**RE: Northbay at Lake Woodmoor, Final Plat SF-16-021 - 1<sup>st</sup> Review Response**

This letter responds to your January 3, 2017 review letter relating to the above referenced project. Responses to review comments are shown in red below.

SHEET
13
13 of 21 Sheets

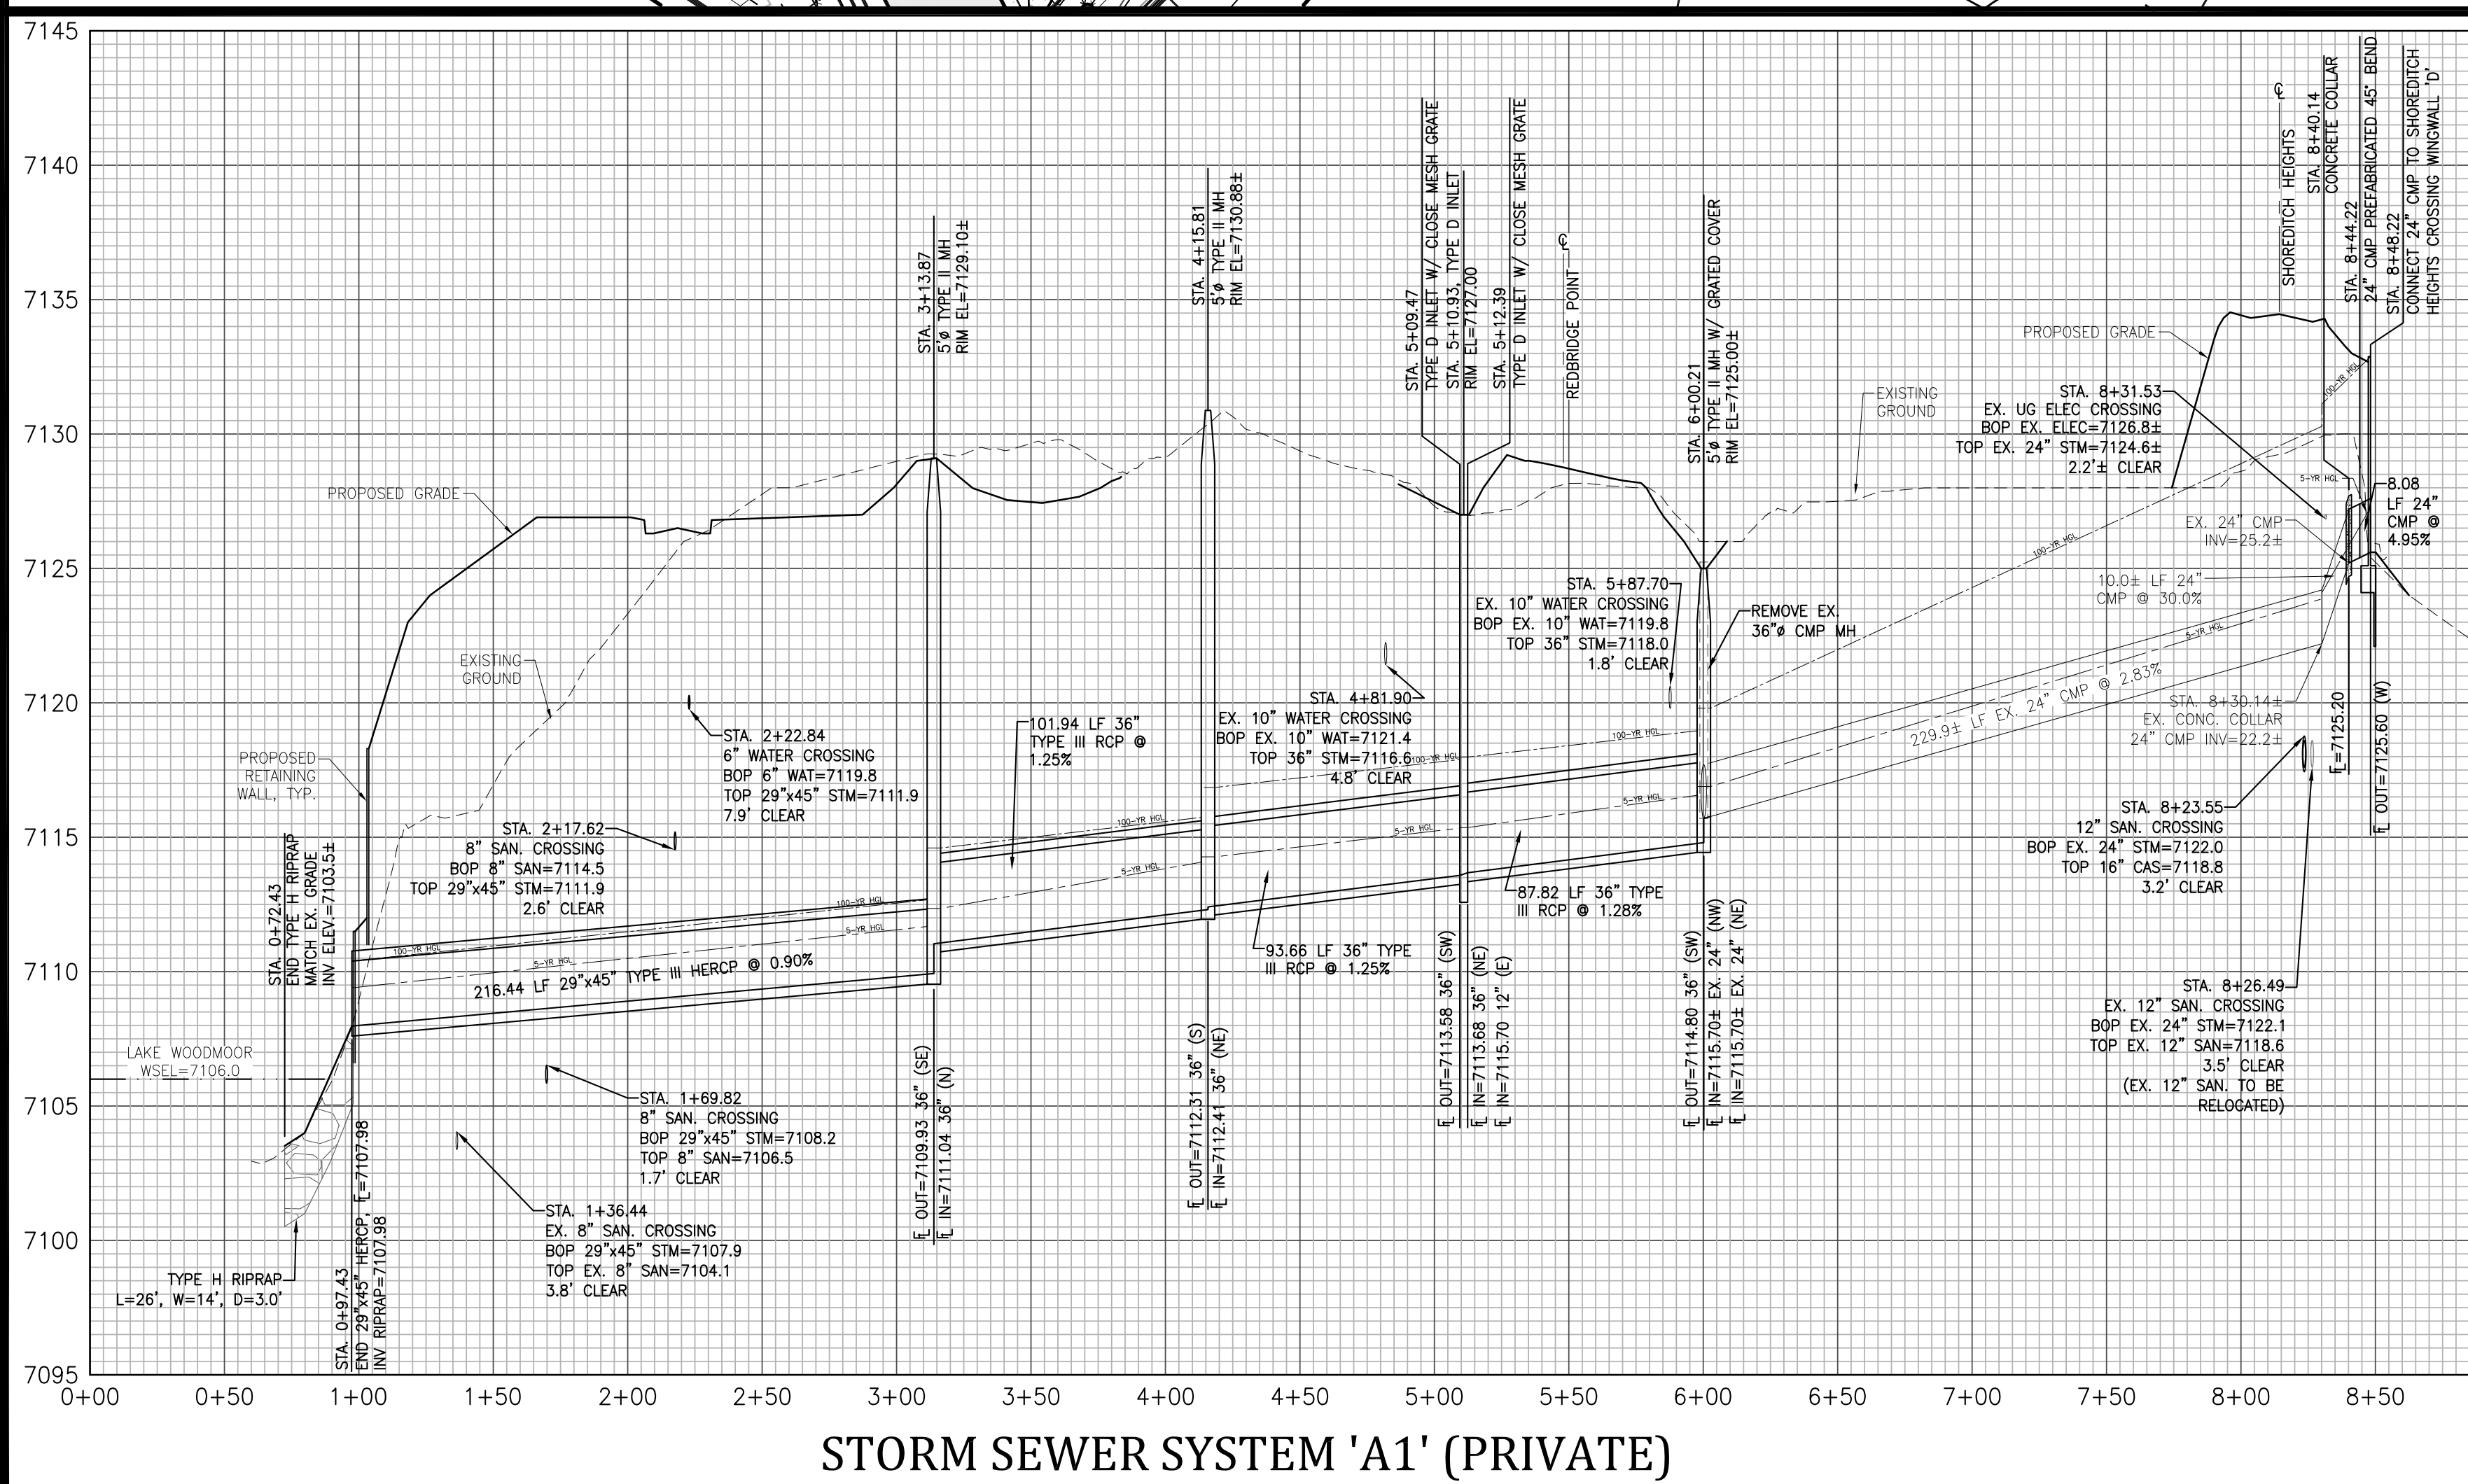
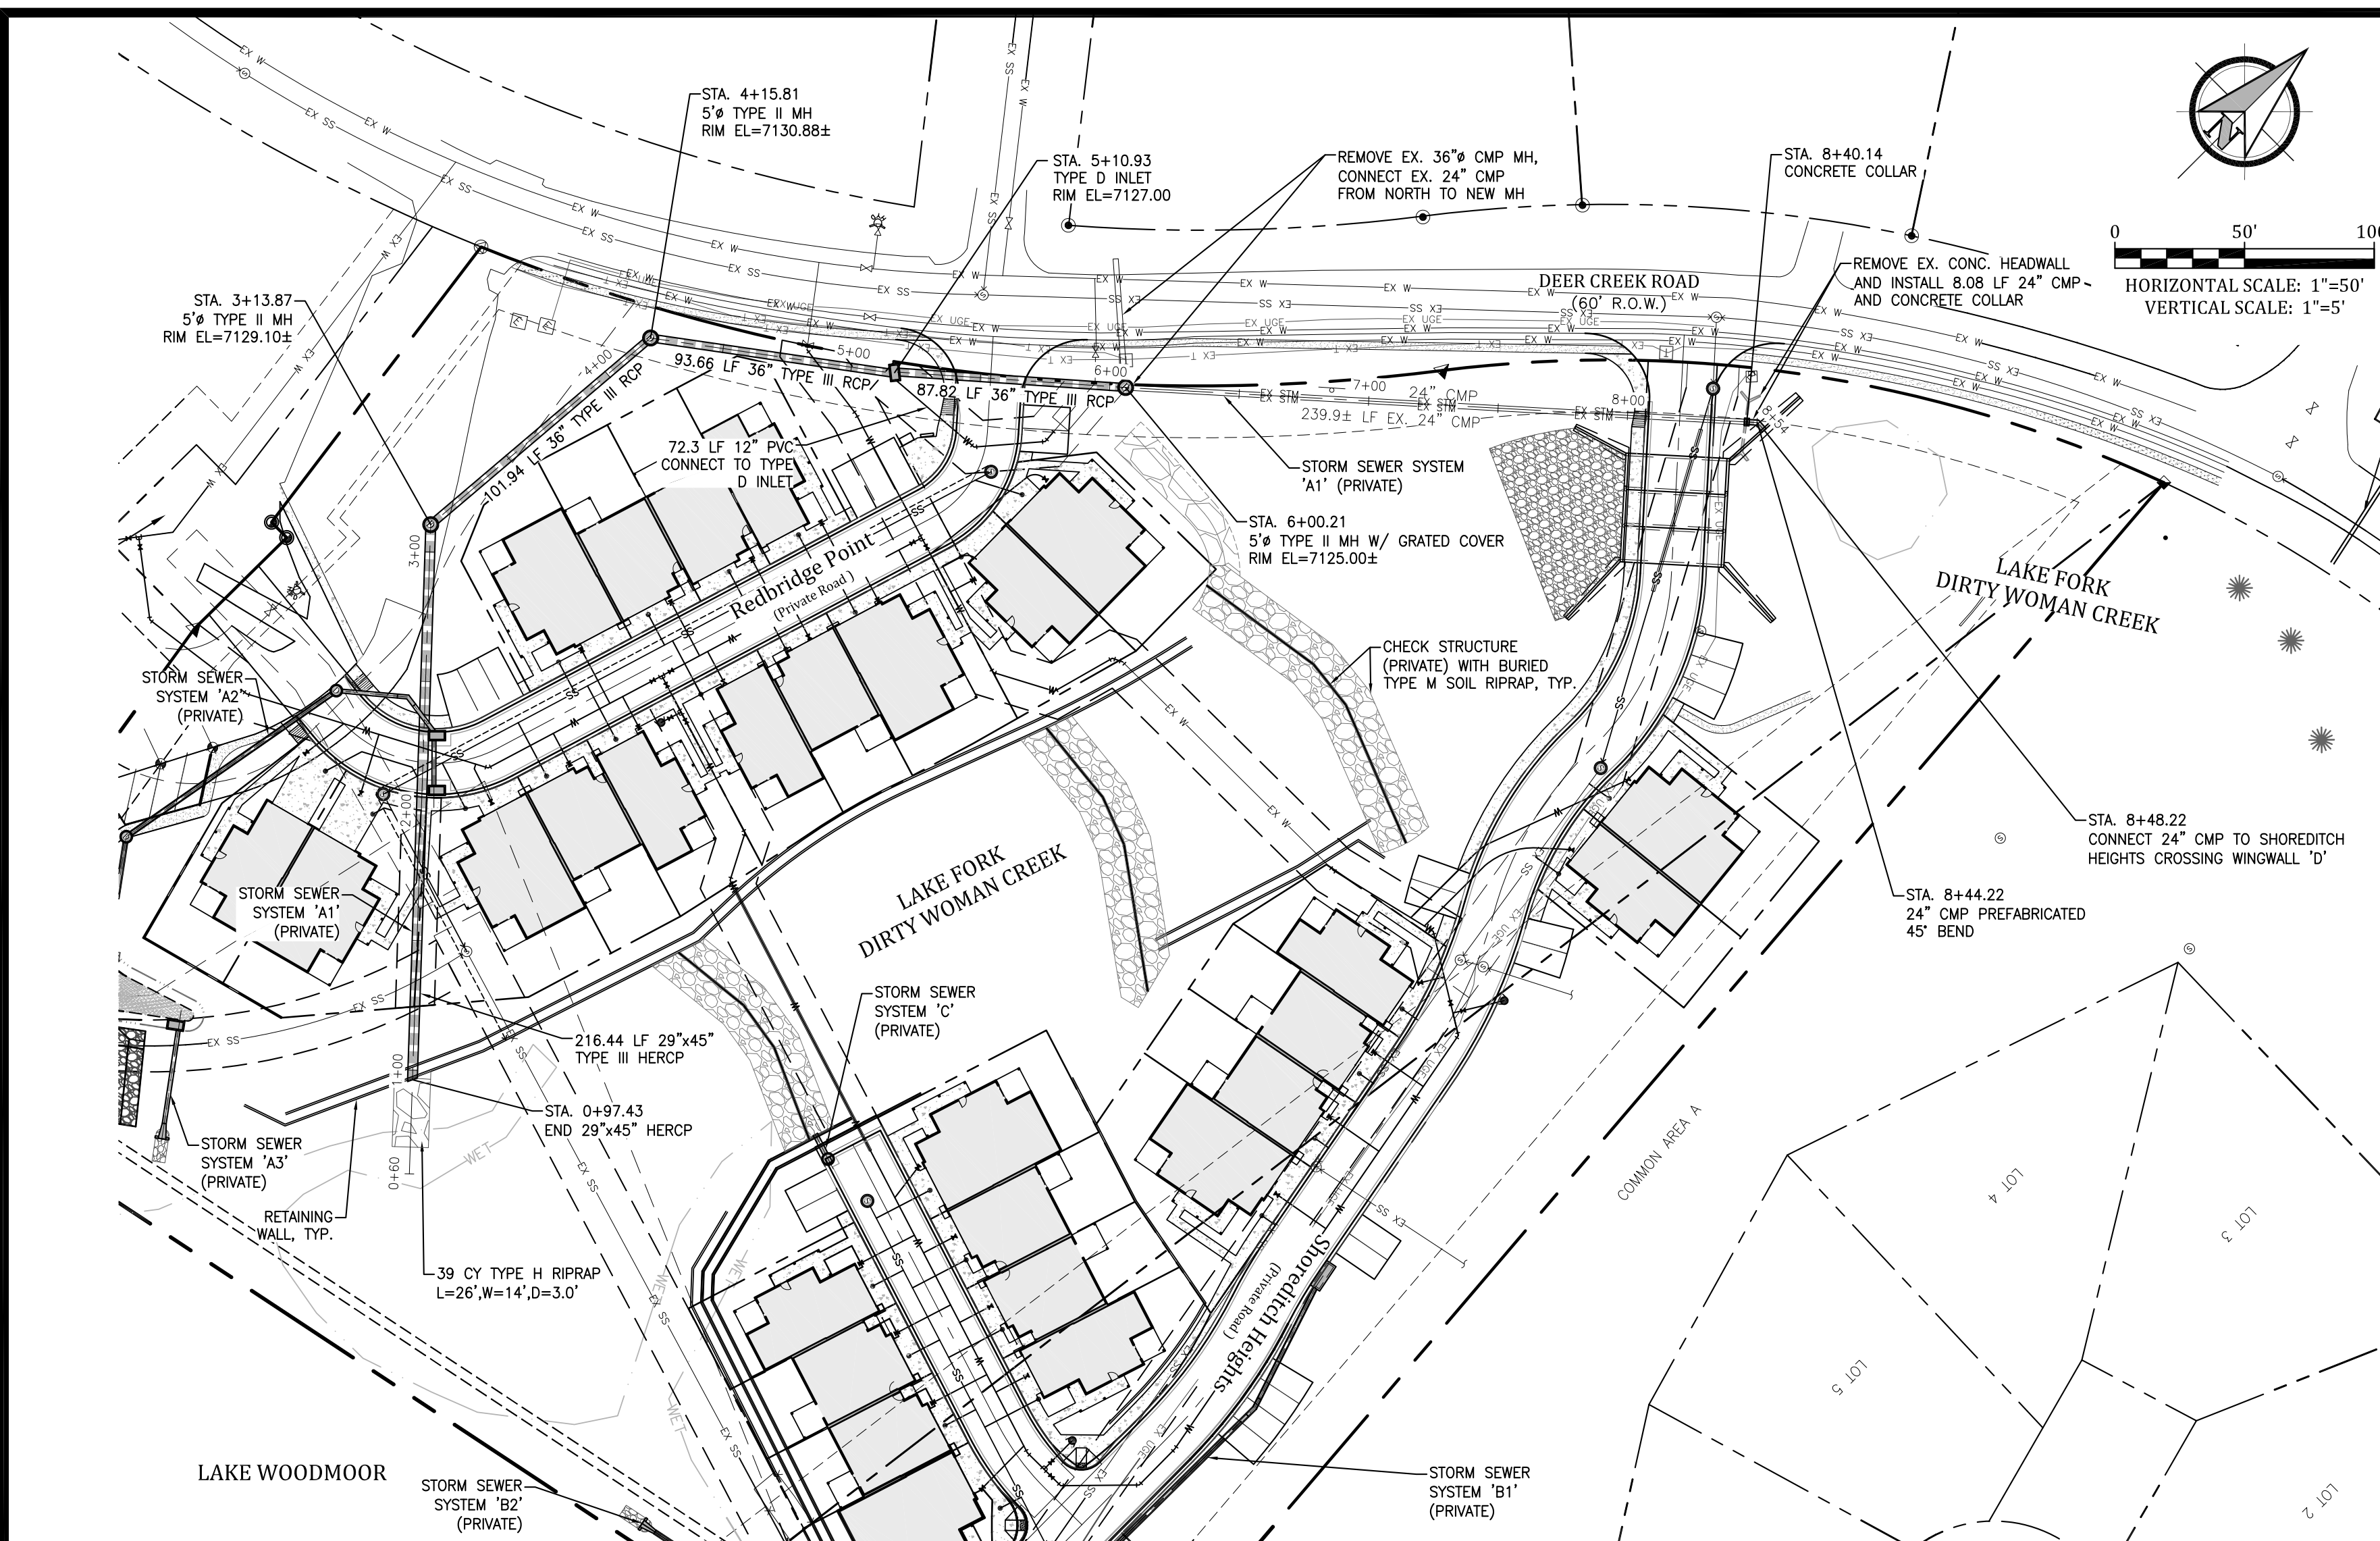
6. Storm P&P sheets (13 & 14)
  - a. Show the proposed lot lines. **Lot lines now shown.**
  - b. Label the storm sewer systems and check structures as Private. **Labels added.**

- c. Place the segment of Storm System 'A' going through Lot 17 in an easement. **Easement added.**
7. Update the check structure detail in accordance with the DBPS. The DBPS shows buried riprap upstream and downstream of the structure. Determine the appropriate riprap pad size. Drop structures may be required if check structure are insufficient to meet the standards in the DCM (see ch 10). **Detail updated.**
